RWDI Australia Pty Ltd
ABN 86 641 303 871

DATE:	August 5, 2021	RWDI REFERENCE #: 2100277
TO:	Joseph Ravi	Atlassian Central
CC:	Amy Kiely	Central Place Sydney
FROM:	Kevin Peddie	Email: kevin.peddie@rwdi.com
	Michael Pieterse	michael.pieterse@rwdi.com
RE:	Atlassian – Office and Hotel Development (SSD-10405) Request for Additional Information

| 9 | Shed roof eve line |

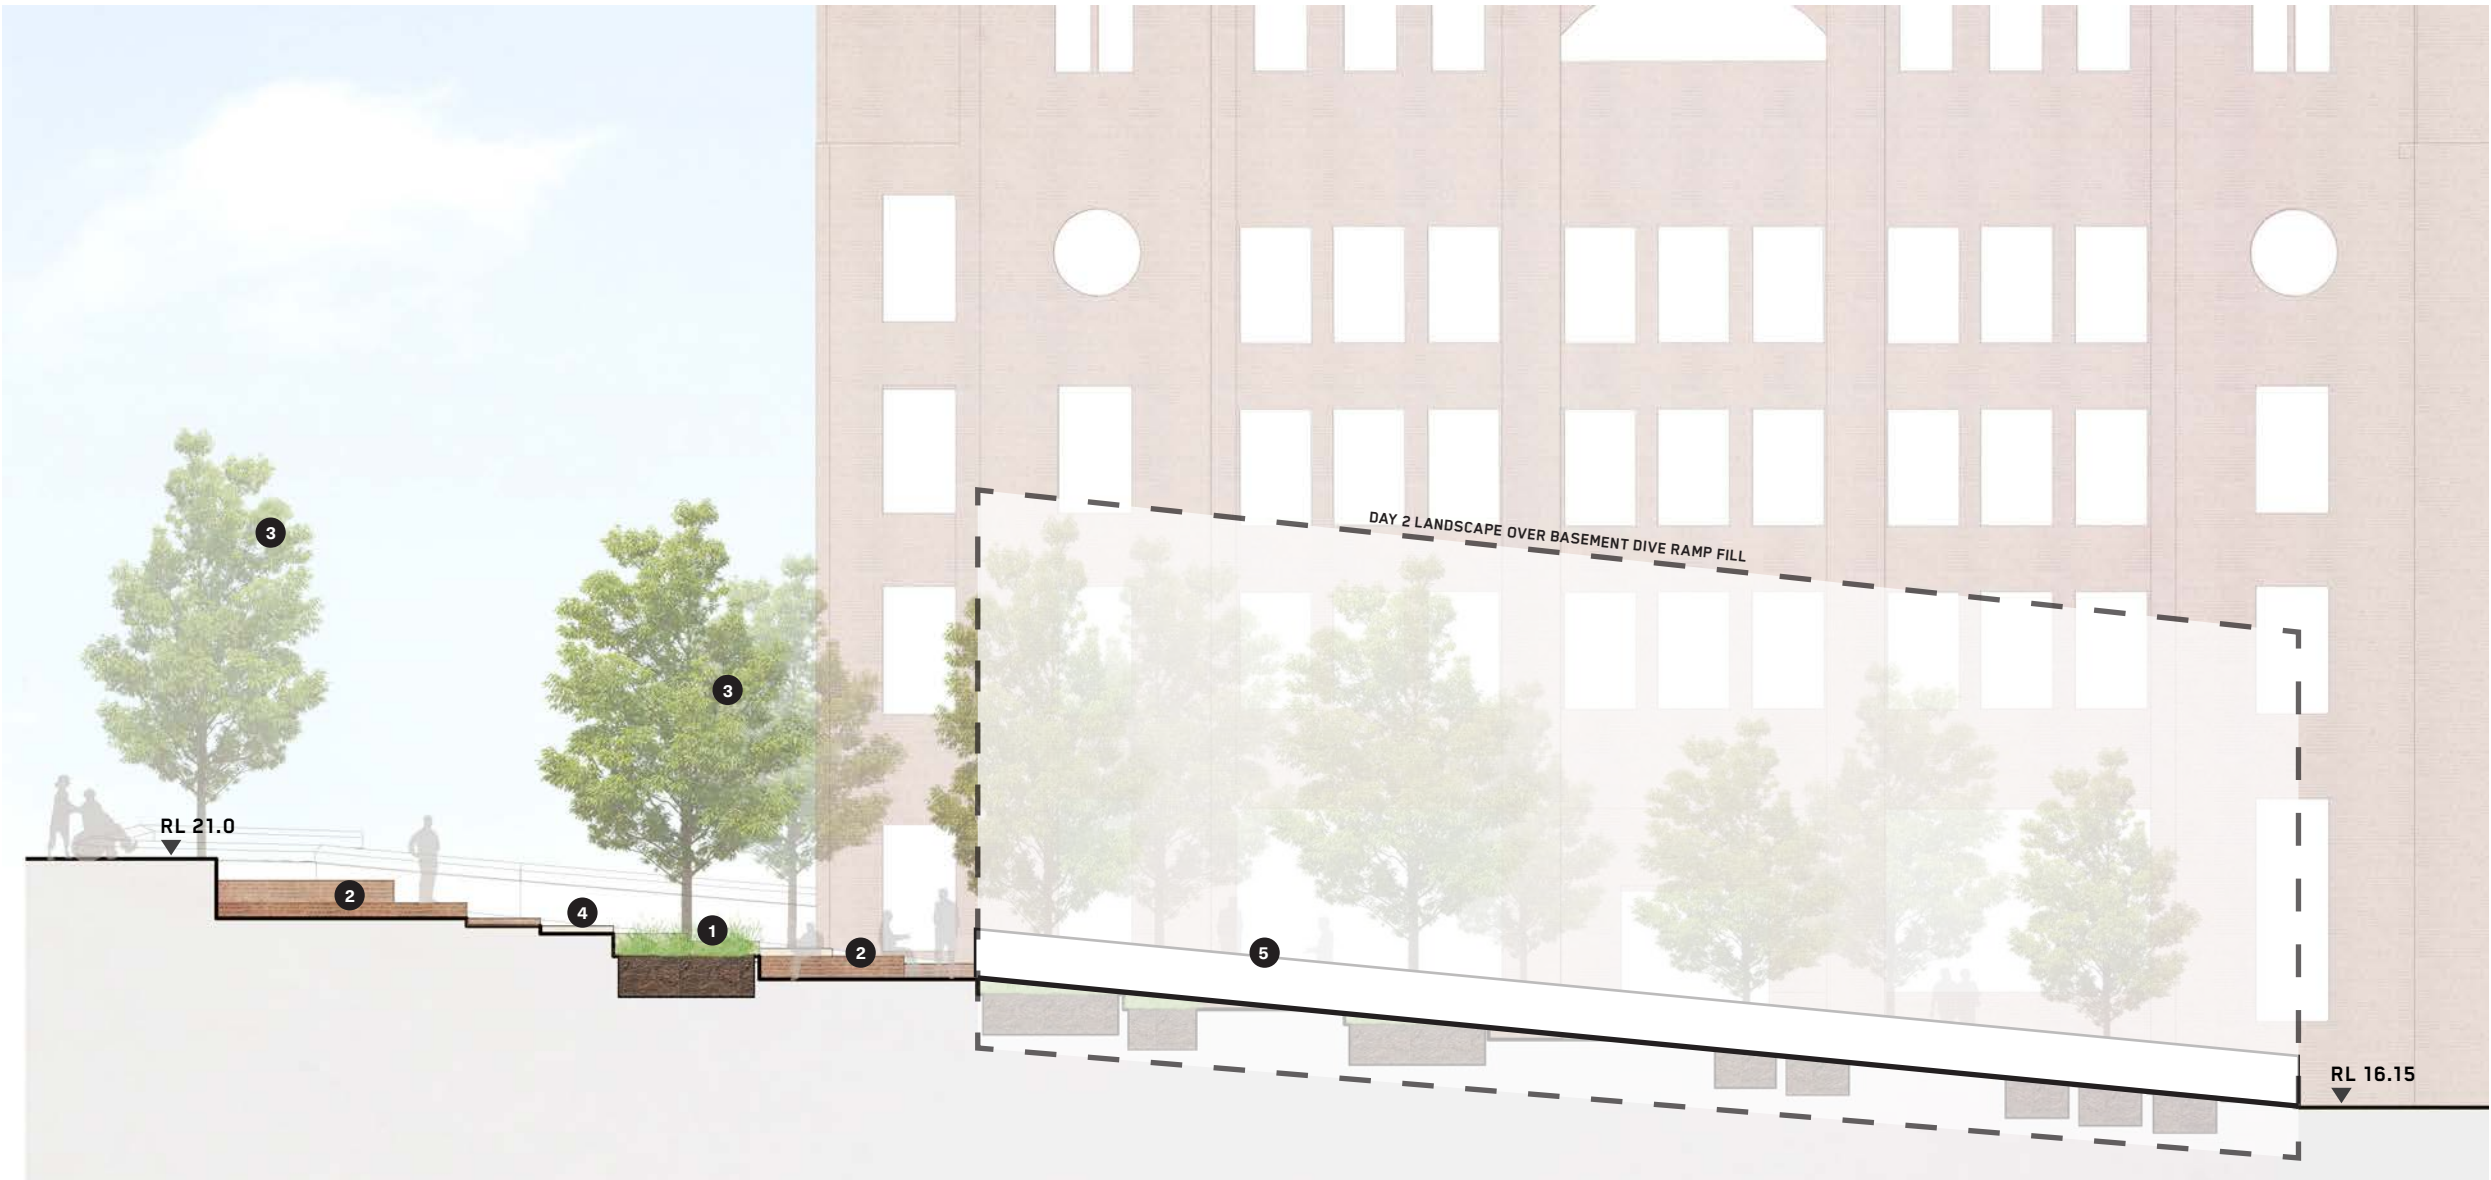
- *Provide an options analysis of any additional mitigation measures which could be implemented within the proposal (rather than Blocks B and C) to*
 - *Meet comfort levels for sitting in the future 'Central Square' and a minimum of 200m² area within Railway Square as required by the Western Gateway Sub-precinct Design Guide.*
 - *Address areas which do not meet the safety criteria established by the Western Gateway Sub-precinct Design Guide in Day 1, 2 and 3 Scenarios*
- *In addition to the built form/heritage concerns raised by Heritage NSW and Council about the bleachers on the Inwards Parcel Shed roof, further consideration should be given to:*
 - *the appropriateness of the wind mitigation measures from a design and visual impact perspective*
 - *the ability to provide wind comfort appropriate for the intended use of the bleachers.*

If an appropriate heritage, design and wind comfort/safety level cannot be achieved consideration should be given to removing the bleachers from the proposal

- *The proposed wind mitigation measures on the bleachers and to the pavilion over the OSD connection (see page 18 of the wind report) are excessive, do not achieve design excellence and are contrary to the draft Western Gateway Design Guide. The applicant's wind report burdens Blocks B and C with resolving uncomfortable and unsafe wind conditions, rather than addressing these issues holistically. The applicant must resolve these issues with their neighbours prior to determination.*

The Parcel Shed Roof area is exposed to the prevailing southerly, westerly and north-easterly winds due to the elevated nature and interaction with the surrounding built form. The wind conditions based on the evolved design of Central Place are presented in Image 3 and should be noted **does not include any mitigation measures**.

The north-western and south-western corners of the bleachers are noted to exceed the safety criteria during the Day 1 scenario and hence required localized mitigation

presented in the RtS. The inclusion of the evolved Central Place Sydney design during the Day 2 scenario improves the wind conditions at the south-western corner of the bleachers such that this area satisfies the safety limit criteria. This is also the case during the Day 3 scenario.

The wind comfort conditions in this area is also noted to generally satisfy the standing criteria without any mitigation measures.

It is noted that the retention of the bleachers as part of the current SSDA is currently being reviewed by the design team.

The wind conditions associated with the bleachers has been discussed in further detail in Section 1.2 above. As noted, the evolved design of the Central Place site, particular the north-eastern corner of the design has improved the wind conditions at the south-western corner of the bleachers such that they will satisfy the safety criteria during the Day 2 and 3 scenarios.
